EF13/5058, DOC 17/375965-01
SSD 7237 MOD1

SSD 7372 MOD2 – O'CONNELL STREET PUBLIC SCHOOL

I am writing to you in reply to your invitation to the EPA to provide a submission in respect of the application to modify the consent for the project.

Figure10: North Elevation showing the Proposed location for the extension of the Plant Platform.

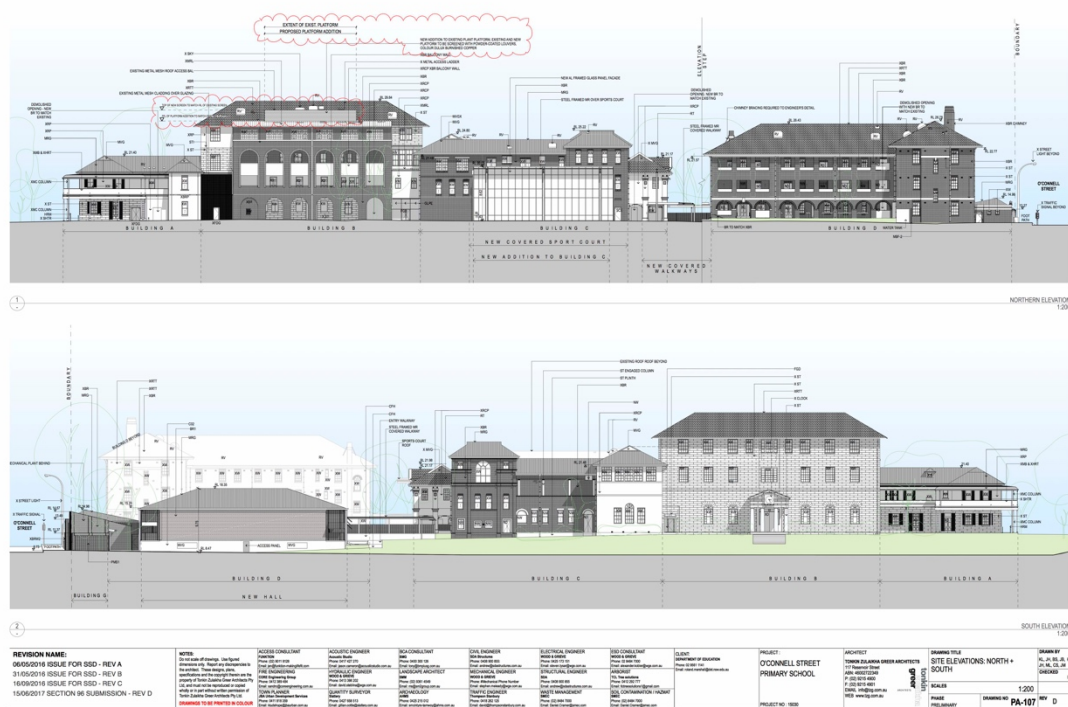
The EPA understands that the modification application is intended to enable inter alia a significant expansion of the building B rooftop plant platform to support condensers serving Buildings A, B and C.

The modification does not appear to address noise emissions from mechanical plant impacting nearby noise sensitive land uses, including the presbytery associated with St Patricks Cathedral. Instead, the Modification Application proposes –

- (section 3.1) installation of a louvered balustrade to minimise the visual impact of new condensers; and
- (section 5.6) noise mitigation measures "... in accordance with the recommendations ..." in the EIS documentation.

Accordingly, the EPA confirms its EIS submission that the proponent be required to ensure plant and equipment does not generate noise that –

- (i) exceeds 5 dBA above the night-time background noise level measured at the northern boundary of the development site, and

(ii) exhibits tonal or other annoying characteristics;
